Reference No: 2023/61/93714/E

Site Address: Land off, Cumberworth Lane, Denby Dale,
Huddersfield, HD8 8RU

DECISION – Reserved Matters – Approve

Officer Report – 2023/93714

Section A-A As Proposed
Scale 1:100

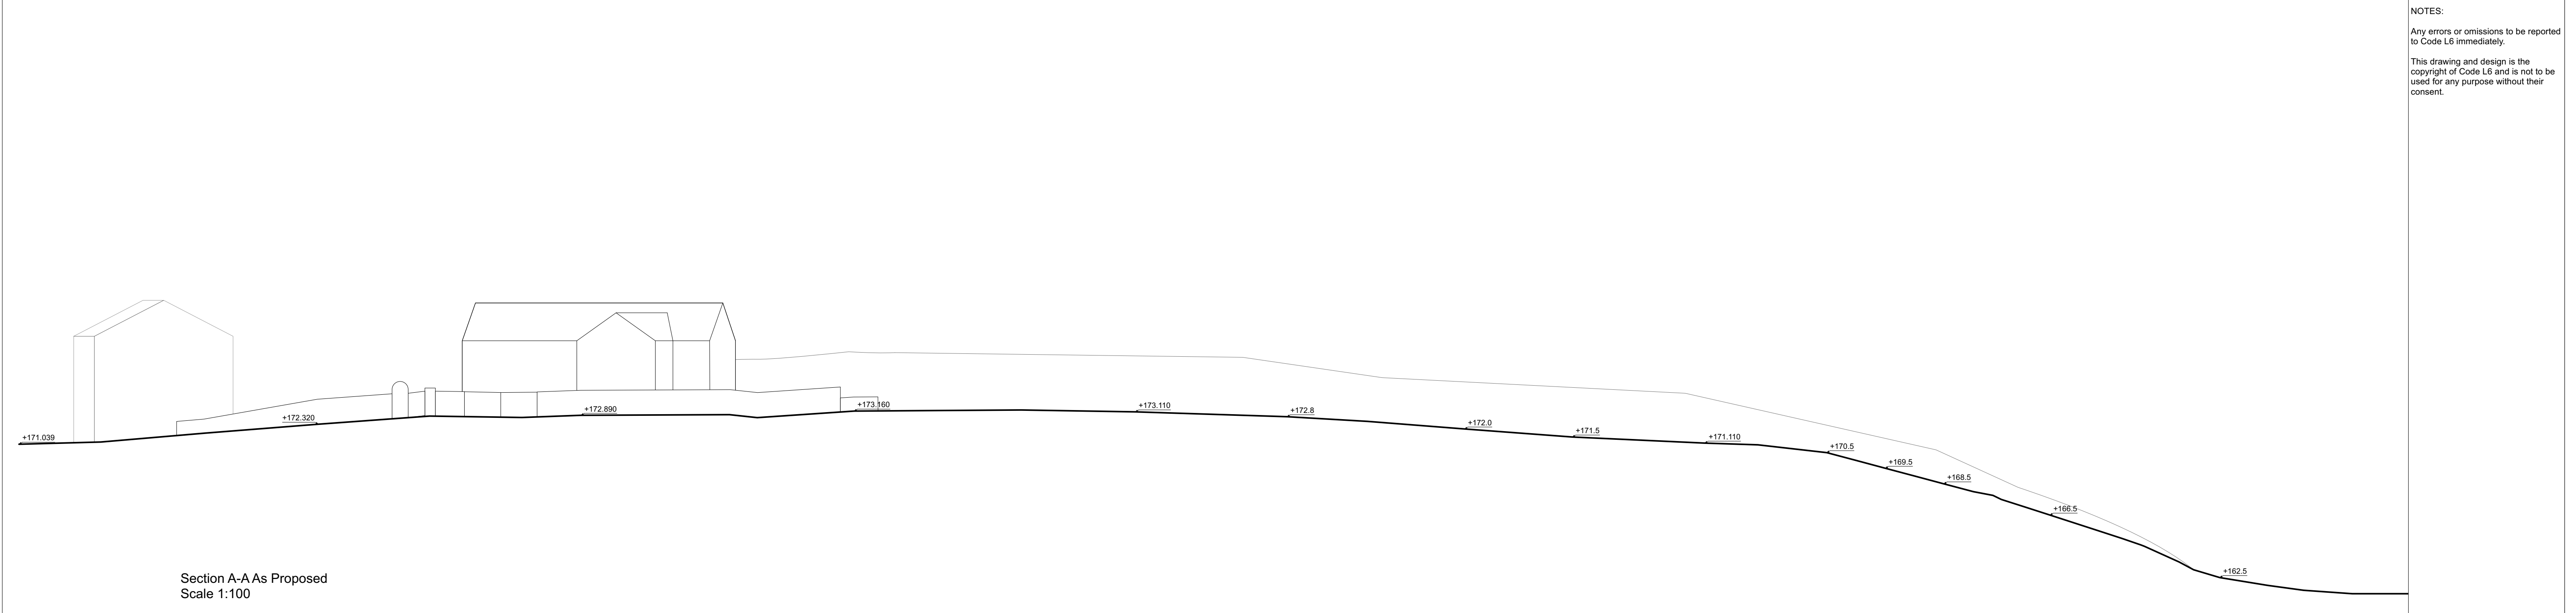
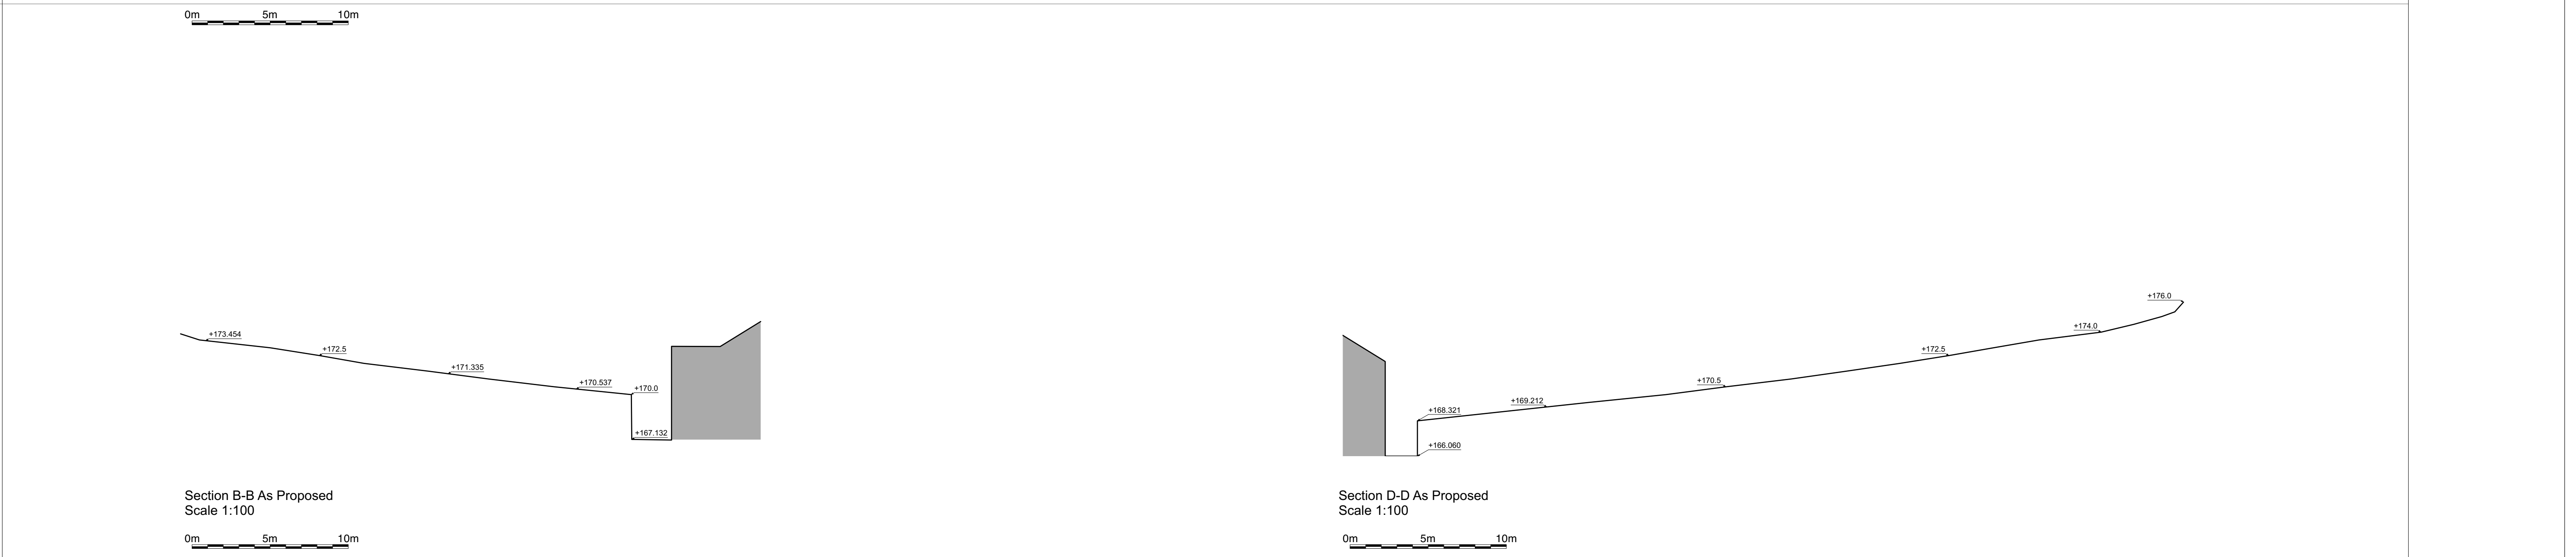
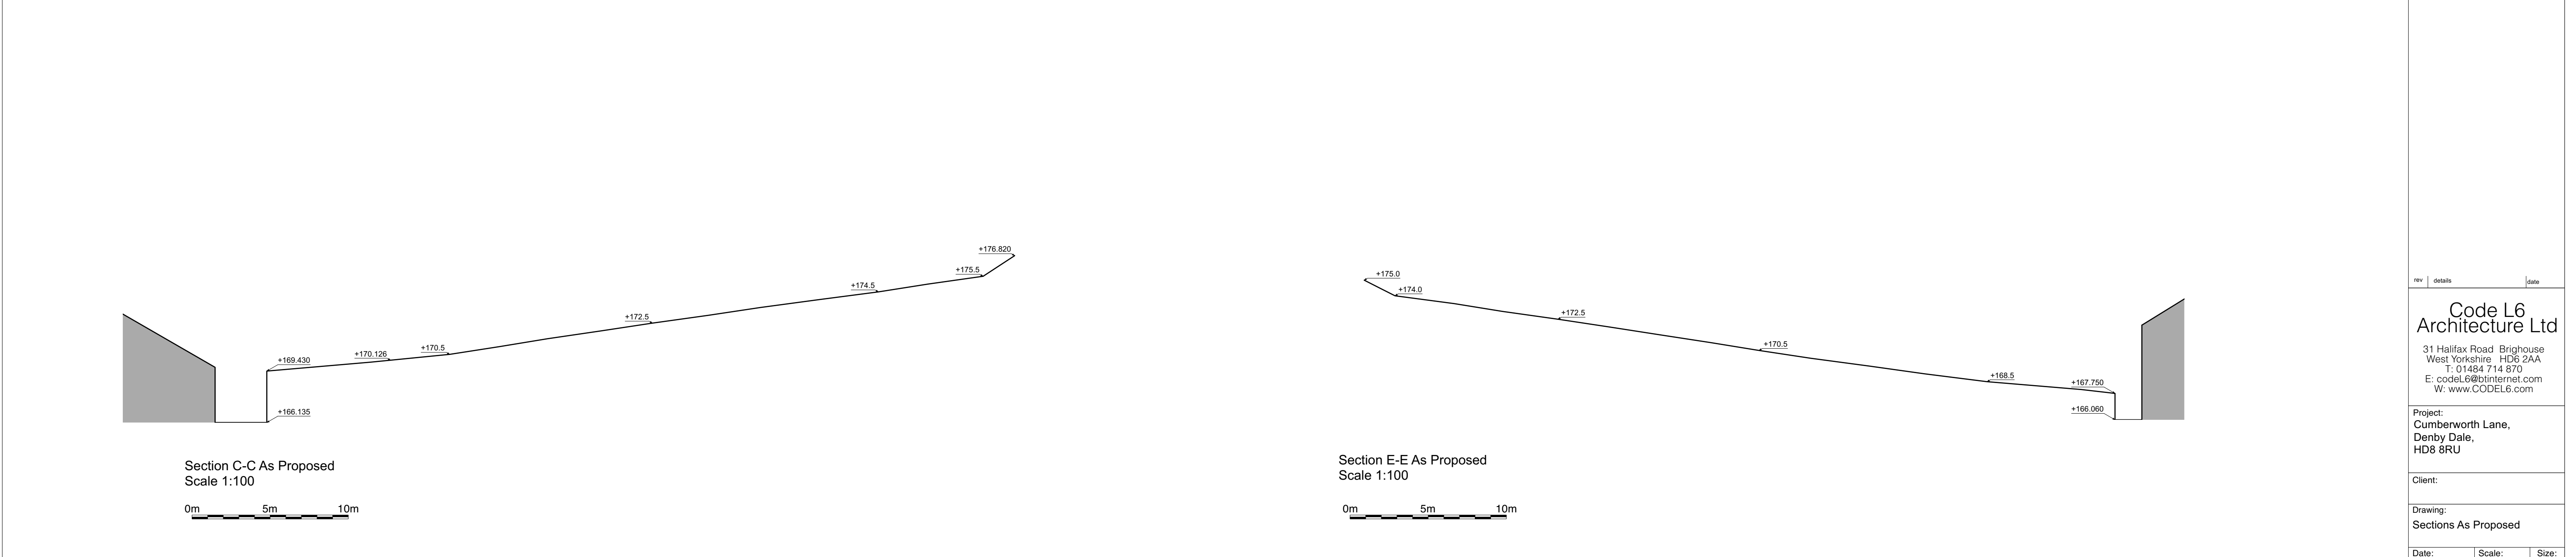
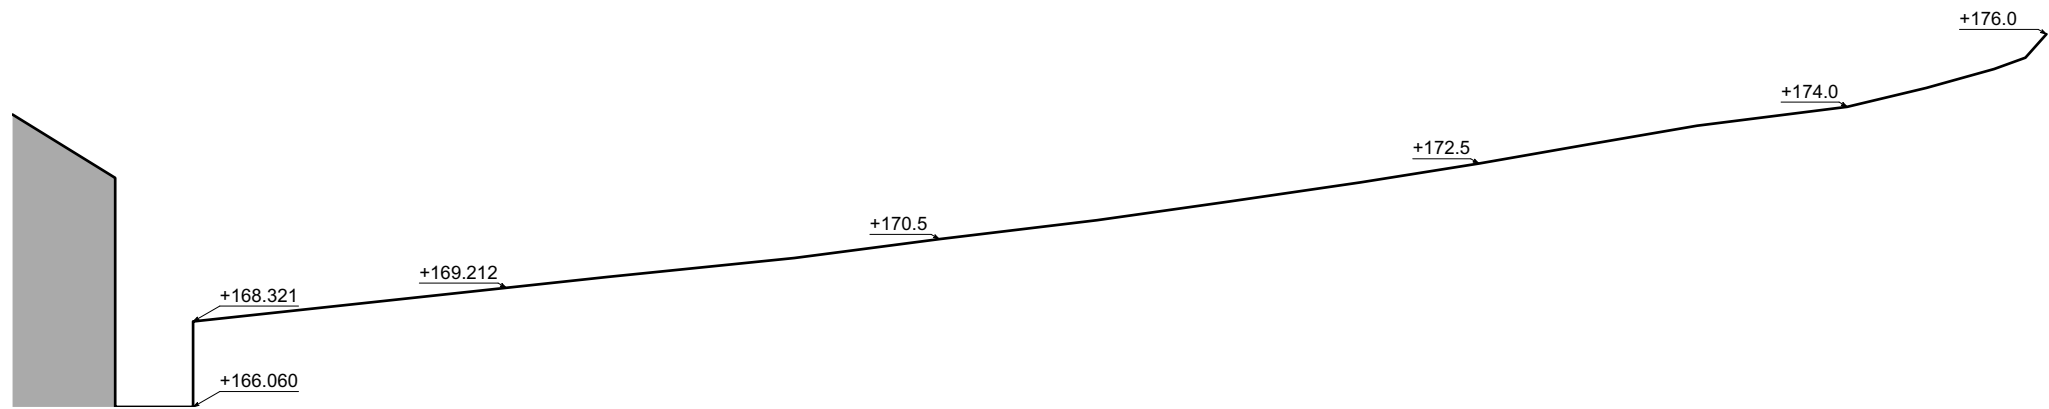
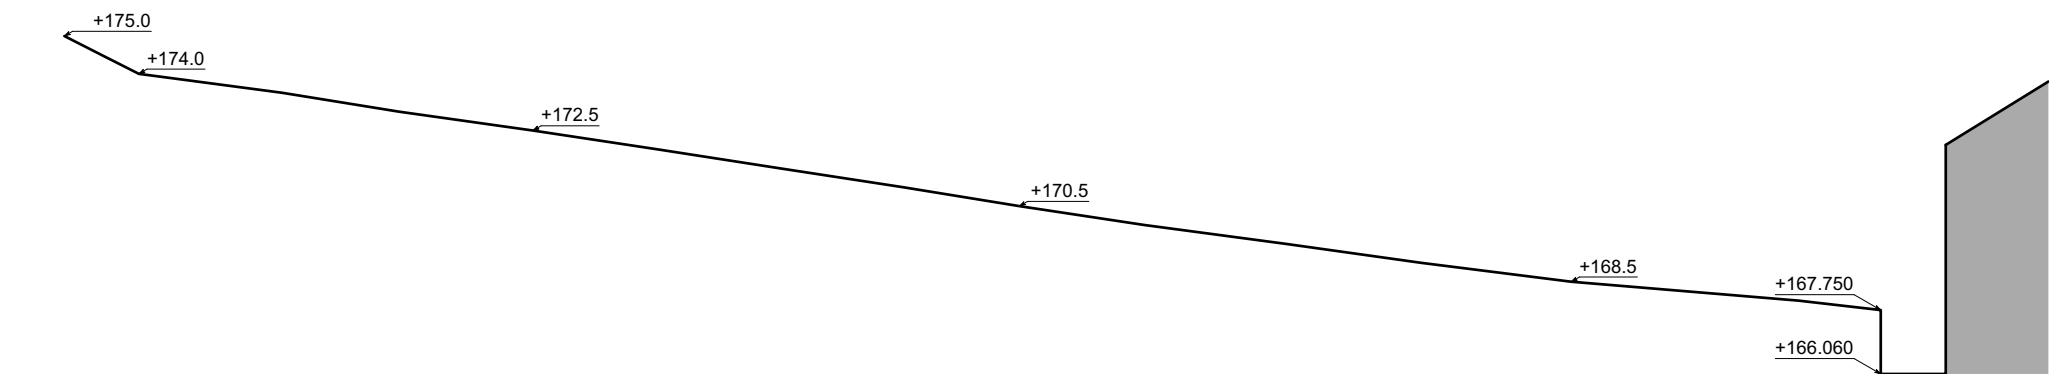
- We believe the development should be set into the hillside rather than built out as this would integrate it better into the landscape and be less intrusive to the properties below. An additional section (between C-C and D-D) would be useful.

It is noted that the dwellings in the southern half of the site would be considerably higher than the nearest residential properties outside the site boundary, and that there would be a significant net increase in ground levels in some places, with the creation of retaining walls. It would, however, be seen in the context of rising land to the rear. It is considered on balance that the proposed development would not dominate its surroundings and that the use of partly three-storey houses would not appear out of place given the variety of house types and styles that exist in the local area. Three-storey dwellings have been built relatively recently at Springhead Gardens. The developer has made the best possible use of the topography of the site in accordance with the aims of Principle 2 of the Housebuilders' Design Guide. The submitted plans and sectional drawings provide a full scheme of finished ground and floor levels. It is considered that the development would not adversely affect long-distance views or the quality and character of the wider landscape.
